Our Ref: Y/167/21/DOC

Approval of details reserved by condition imposed under Y/49/21/RES relating to conditions 3-in curtilage cycle stores; 4-Landscaping Measured Works Schedule, 5-alternative surfacing to those pathways shows as hoggins, 7-proposed location of required fire hydrants, 10-proposed footpath/cycle links between the ends of the cul-de-sacs on perimeter of site are at least 3m wide and feature some form of modal filler, 11-continuous footway outside plot 214 & 12-retention of existing metal estate fencing around sheep field & replacement of damaged sections and removed old sections.

Land East of Drove Lane Yapton BN18 0EB

Arun District Council have decided to **REFUSE details reserved by condition for the following reasons:**

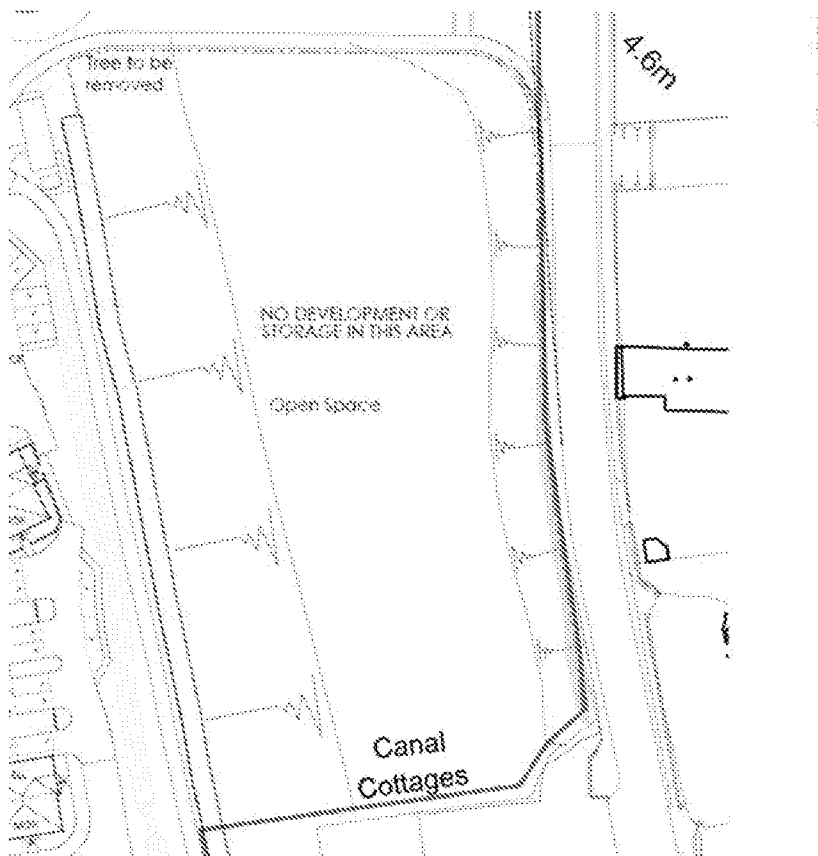
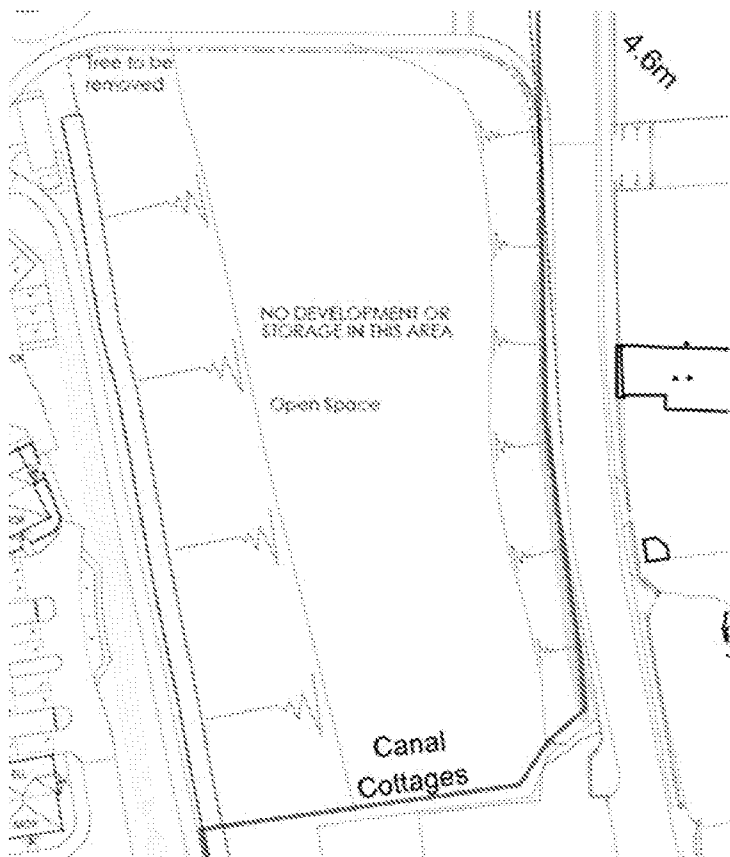
This condition requires the submission of plans and details to show the retention of the existing metal estate fencing around the sheep field and the replacement of damaged sections with replacement fencing that is as close a match to the existing as possible. You have provided a plan which indicates that a significant section will need to be replaced and you have provided a photo of a replacement

fencing type. There are no details however of the make/model/design of said fencing. It is also unclear how the existing sections will be treated to enable the old and new to match as best as possible. Without this information, it is not currently possible to agree to the discharge of this condition and you will need to make a new submission. Our Conservation Officer has stated that he is happy to attend the site with you to discuss options in order to enable you to make a successful resubmission.
